Subject: FW: LU/218/20/PL & LU/219/20/L - Flintstone Centre - WITHDRAWALS

Status: PROPOSED

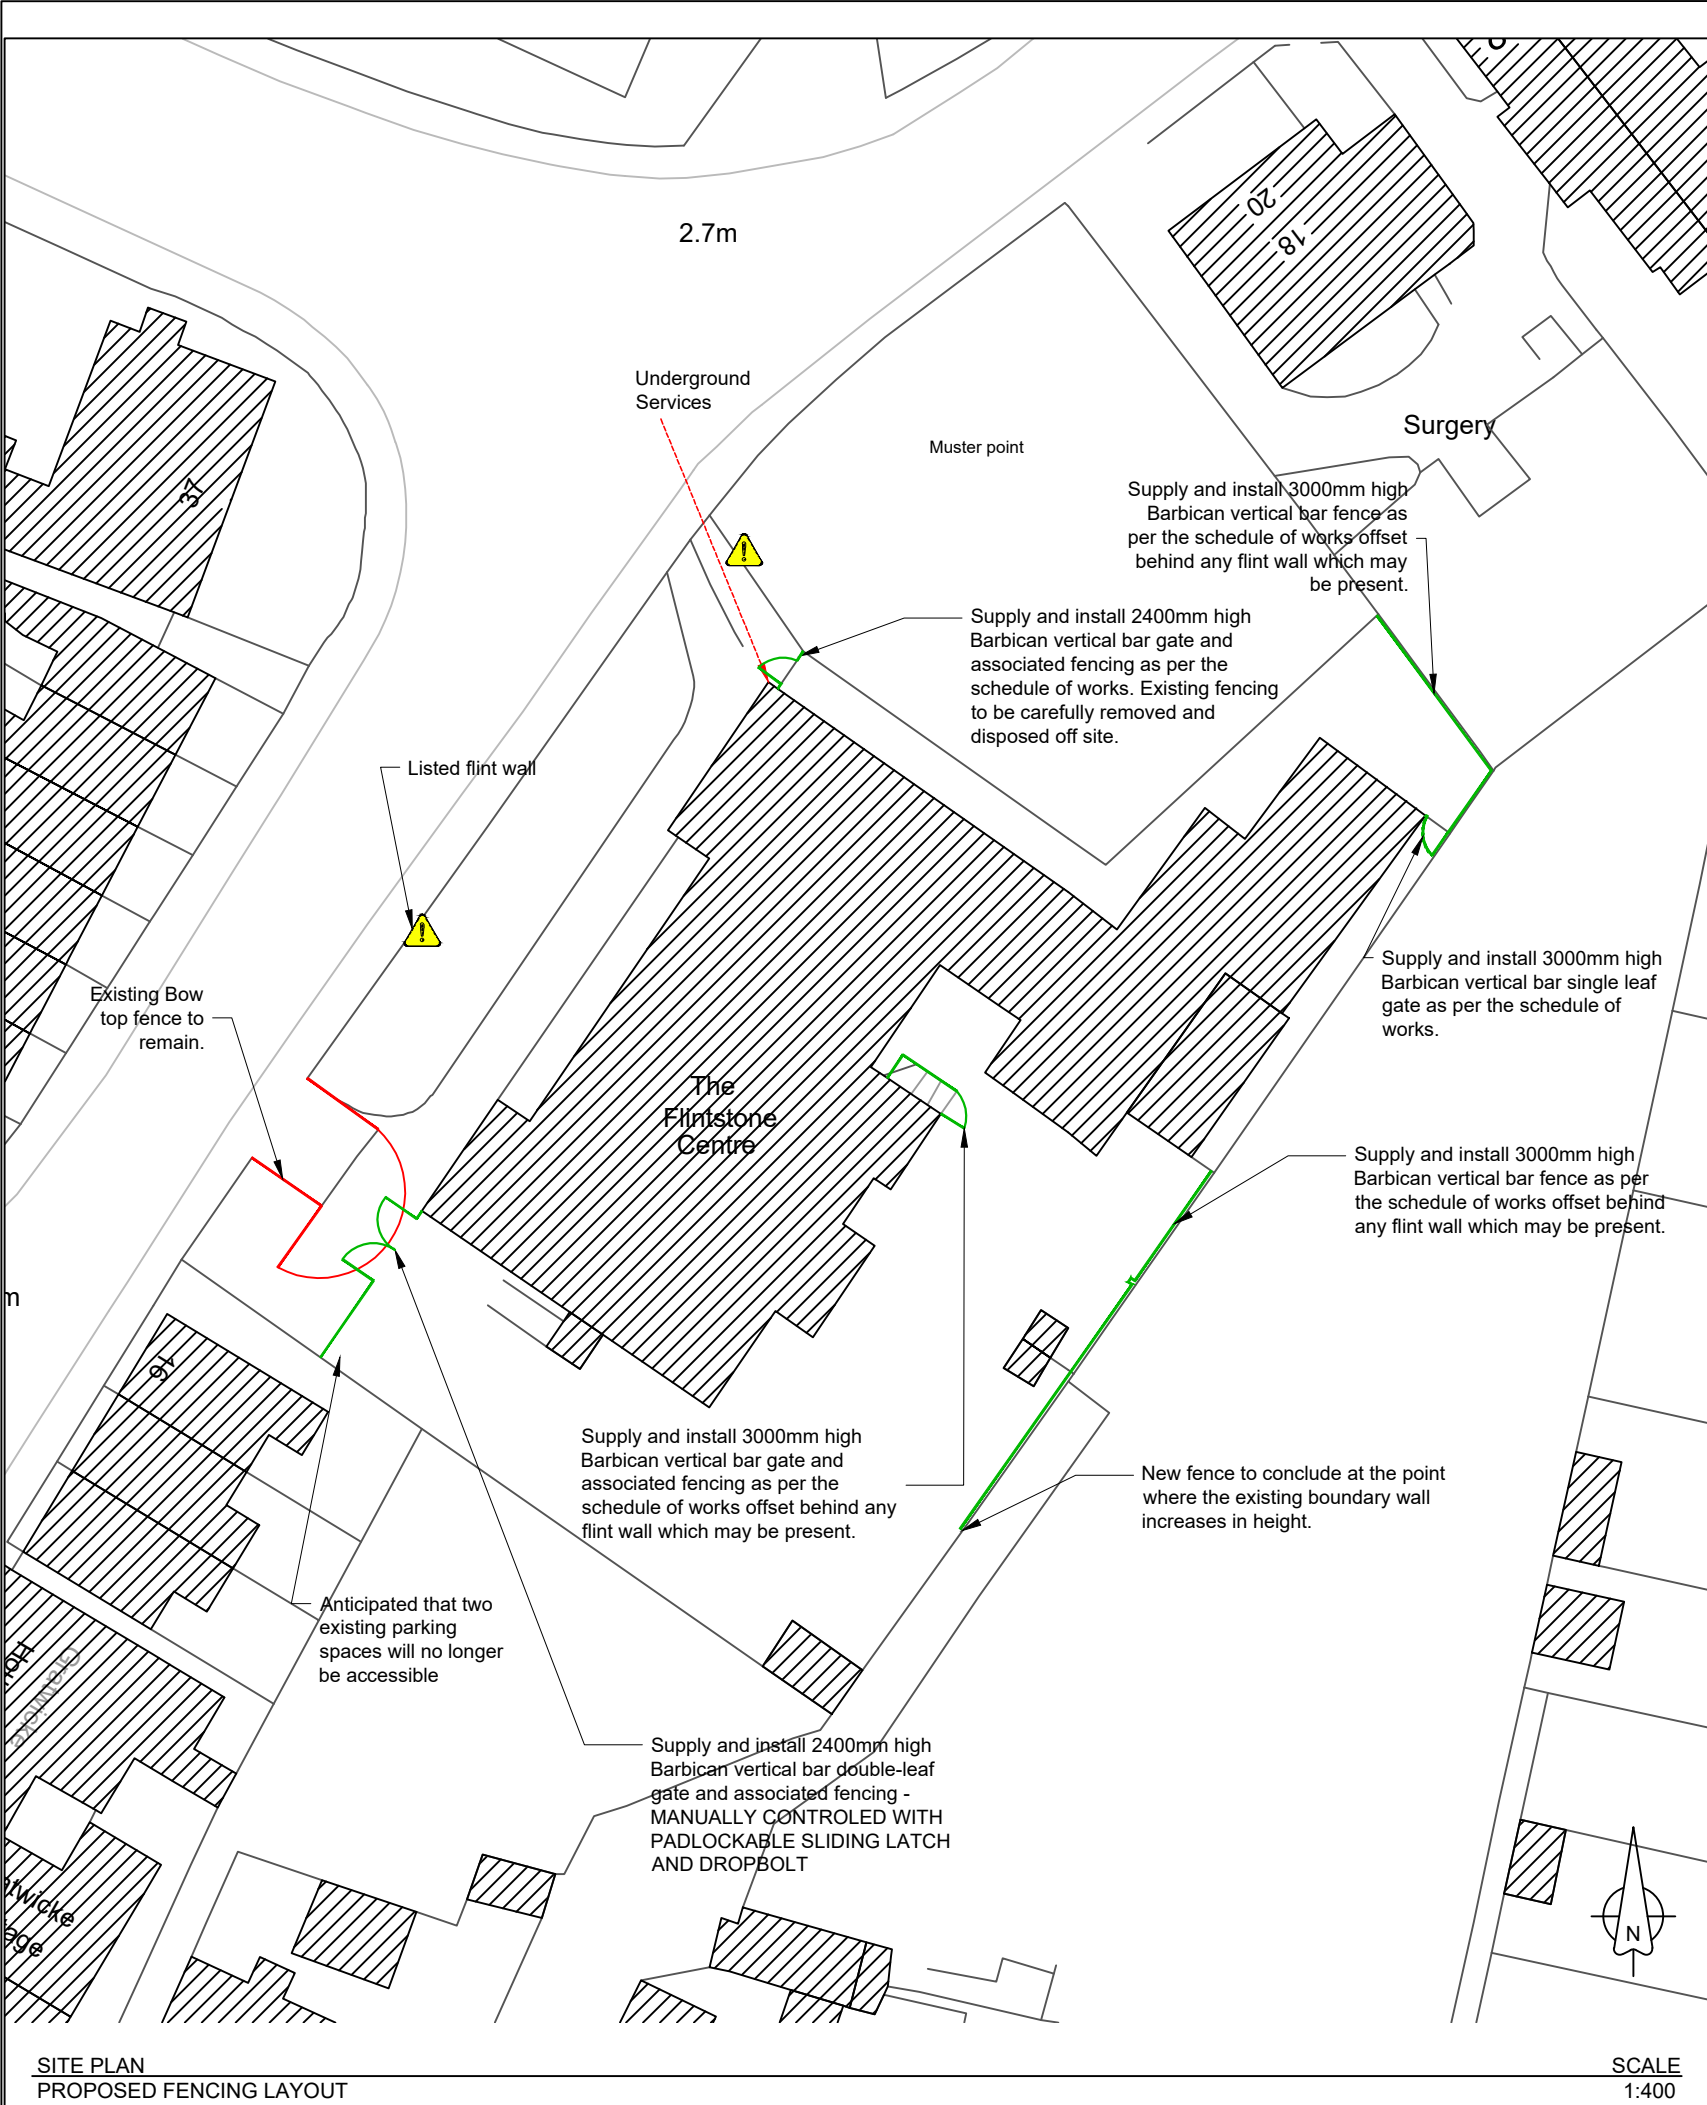
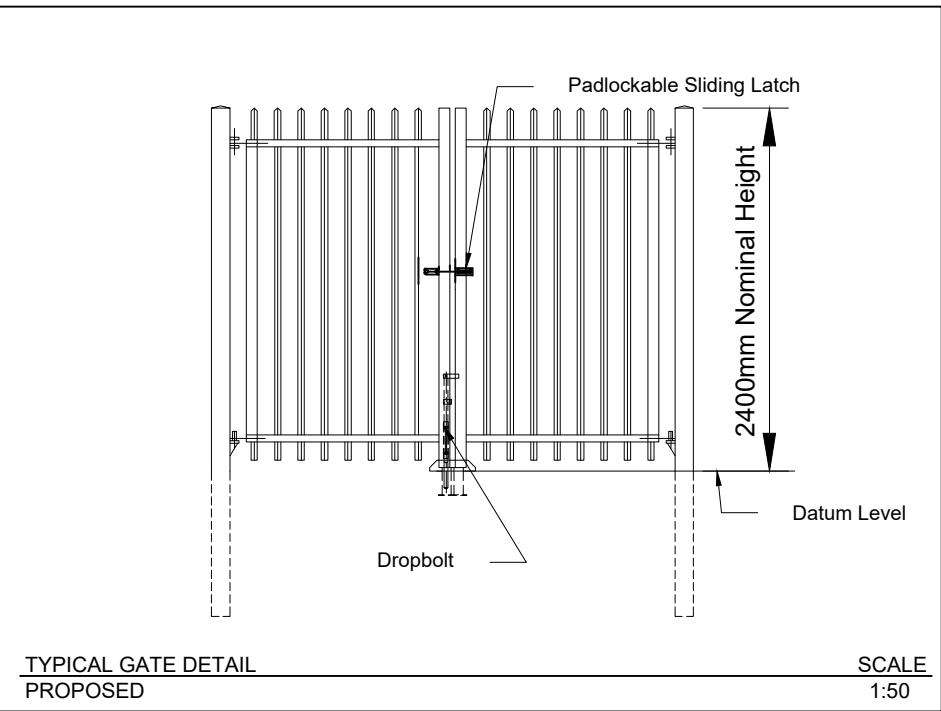
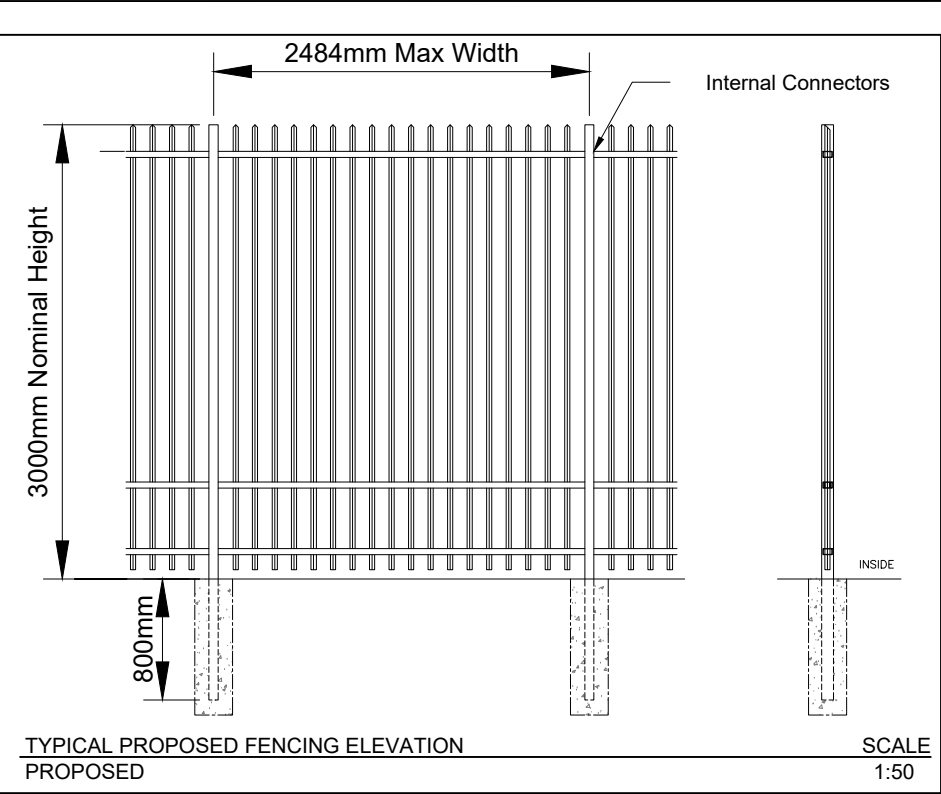
Re your queries below, I did discuss this with the Conservation Officer and we cannot provide a definitive height and design that would be acceptable – perhaps nearer the height of a regular (2m) fence and while the black painted metal is not in and of itself the issue maybe a less utilitarian standard design and a more decorative design appropriate to the listed building. Also would need to be set back further from front building line i.e. around line of the side ramp/entrance door. Probably the best thing for you to do is submit a few options to me informally in due course and I can pass them onto the Conservation Officer to take a look and provide comments.

- Due to the siting, height and design of the proposed fencing/gates to the front right hand side of the building (which would be most visible in the street scene) the proposals would have a harmful impact on the significance/setting of the listed building and the character and appearance of the Conservation Area. The Conservation Officer has raised concerns in this regard, and the Council's Conservation Area Advisory Panel have raised an objection on these grounds. NB the sections of fencing and gate and the other sides and rear are considered acceptable (given their limited visibility and existing section of fencing/gate left hand side of building).

*NB I have discussed with my Manager of the possibility of you submitting new applications whereby this section of fence/gates is reduced in height, has an amended design, and re-sited set back from the façade/front building line of the building and that this may be acceptable in heritage terms (since this would reduce its visibility and prominence in the street scene, the impact on the listed building's façade, and the existing tree provides some screening).
